Online Comment

Application H04-0445-20
Location Dave Cook Engineering Quadring Road Donington PE11 4TB
Proposal Details of site levels, contamination ground report, materials, surface water drainage, landscaping, boundary treatment, storage of waste bins and external service boxes (Conditions 3, 7, 8, 9, 10, 11, 12, and 13 of H04-0894-17)

Name Black Sluice Internal Drainage Board
Address Station Road Swineshead Boston PE20 3PW

Date Submitted 29-07-20
For/Against Comments

Drainage Layout

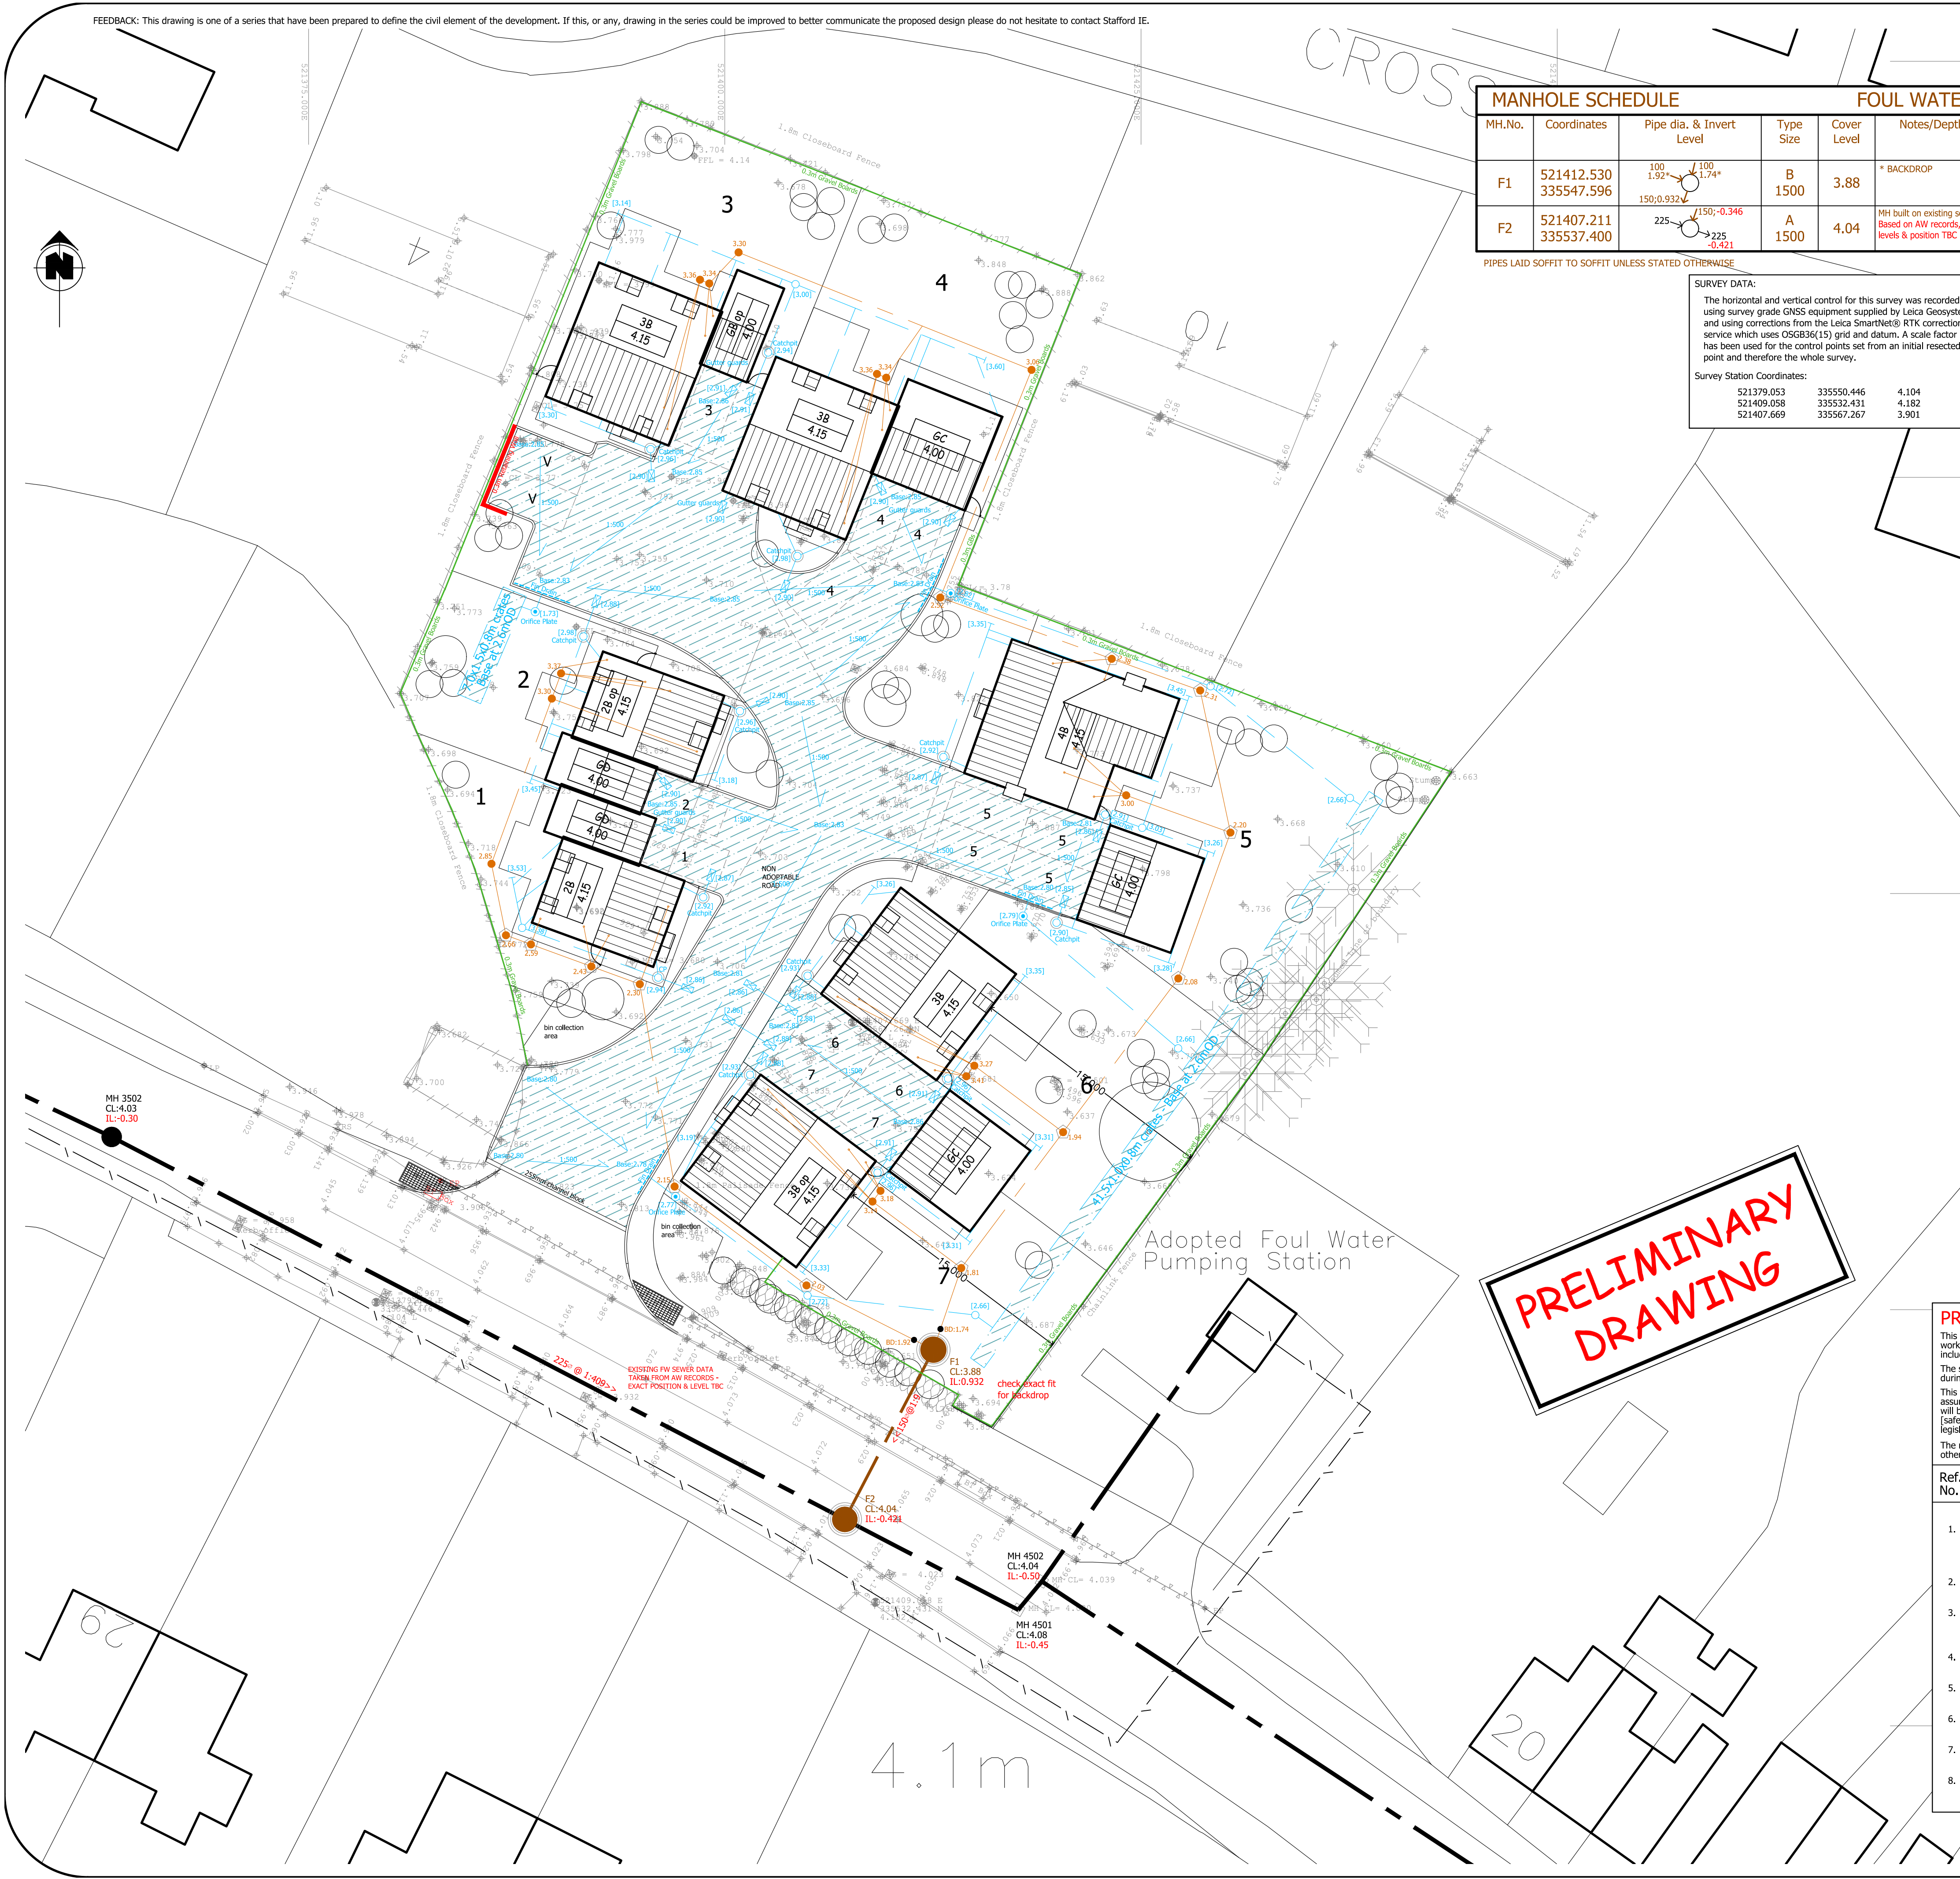
Surface water - it would appear that the applicant intends to use soakaways/infiltration as the means of surface water disposal across the site. However, the Board can find no evidence submitted to the LPA (as the approving authority) to prove that soakaways/infiltration will be suitable for the site. Until such evidence is presented, the Board deems that the surface water scheme is unsuitable until proven otherwise. If soakaways are subsequently proved unsuitable, then the applicant must submit full details of an alternative scheme to the LPA for consideration. Discharge into any watercourse, open or piped, will require the prior written consent of the Board.

Management - if the proposed surface water scheme proves suitable, then the Board is concerned as to whom will be responsible for the future maintenance of the scheme, particularly where the crate soakaways are to be located within private garden areas.
